***60 Charlotte Street, Campsie  
(Former Sunbeam Site)***

***MP 08\_0087 MOD 2 – Modification to the  
approved Stage 1 Project Application***

Director-General's  
Environmental Assessment Report  
Section 75W of the  
*Environmental Planning and Assessment Act 1979*

November 2012

**REDUCTION RATIO** 1:1500  
**LEVEL DATUM**  
**DATE** 1 JUNE 2009  
**SHEET** 1 OF 1 SHEETS  
**REFERENCE No.** 14200\_1ST1

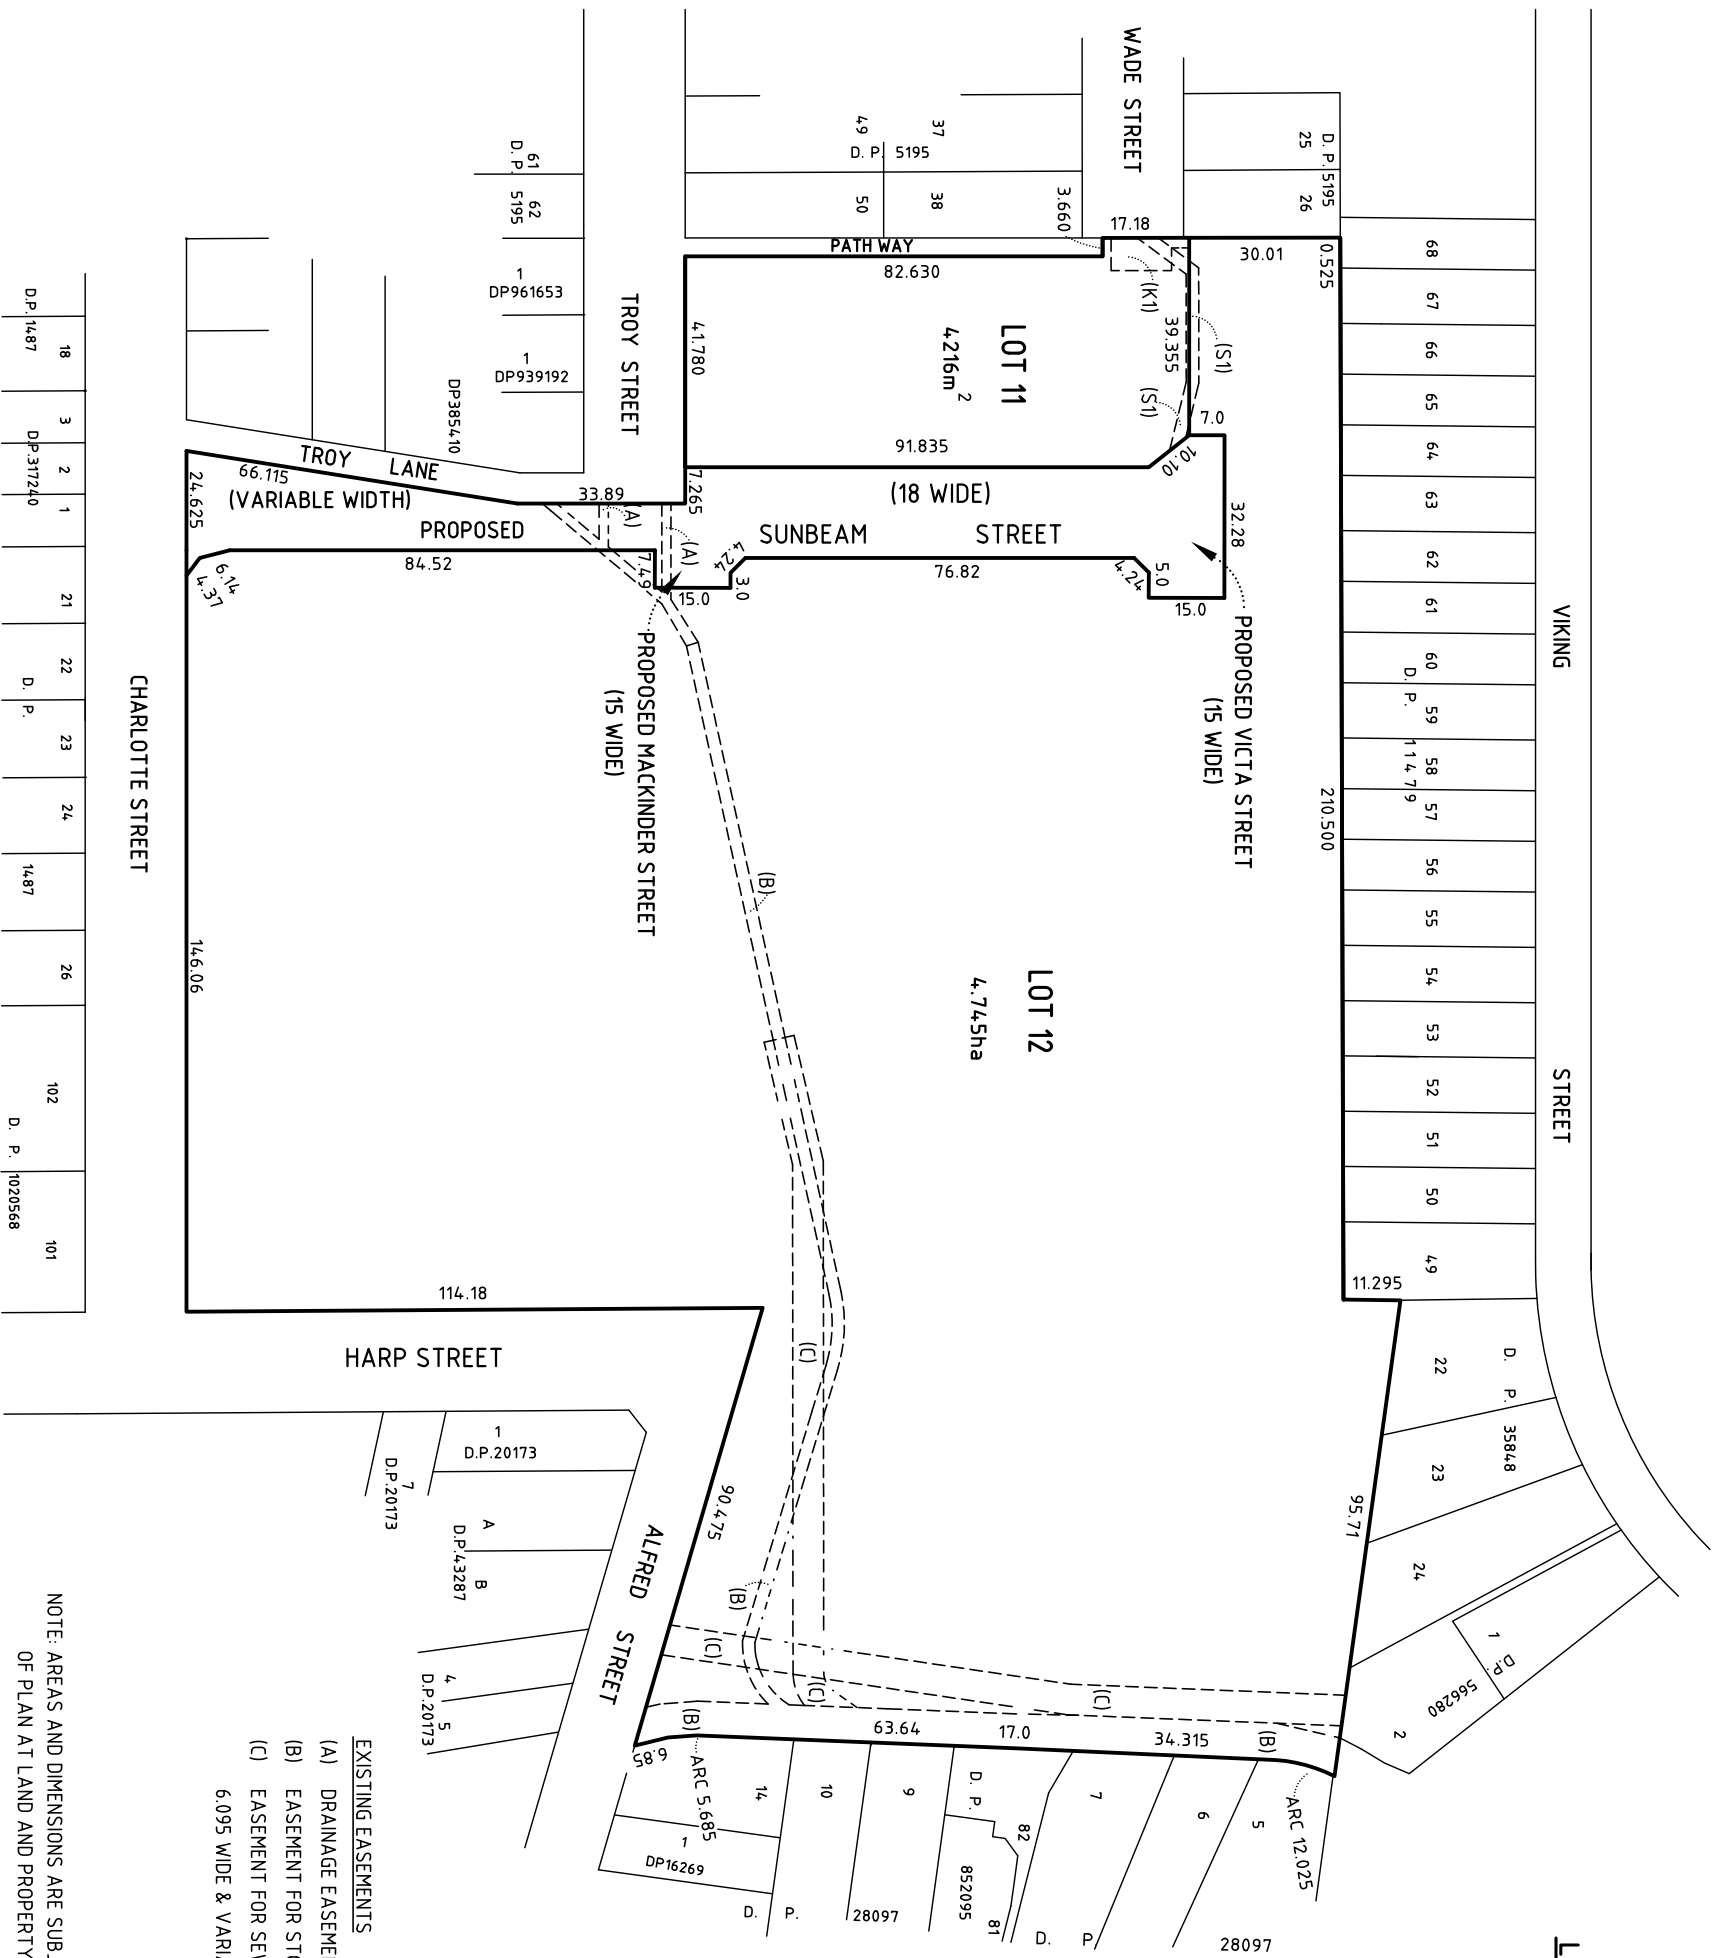
Plan	Modification and reason
14200_1ST1	Easement on Lot 11 has been amended.
14200_1ST2	Easement on Lot 22 has been amended.
14200_1ST3	Easement on Lot 31 has been amended.
14200_1ST4	Easements have been amended.
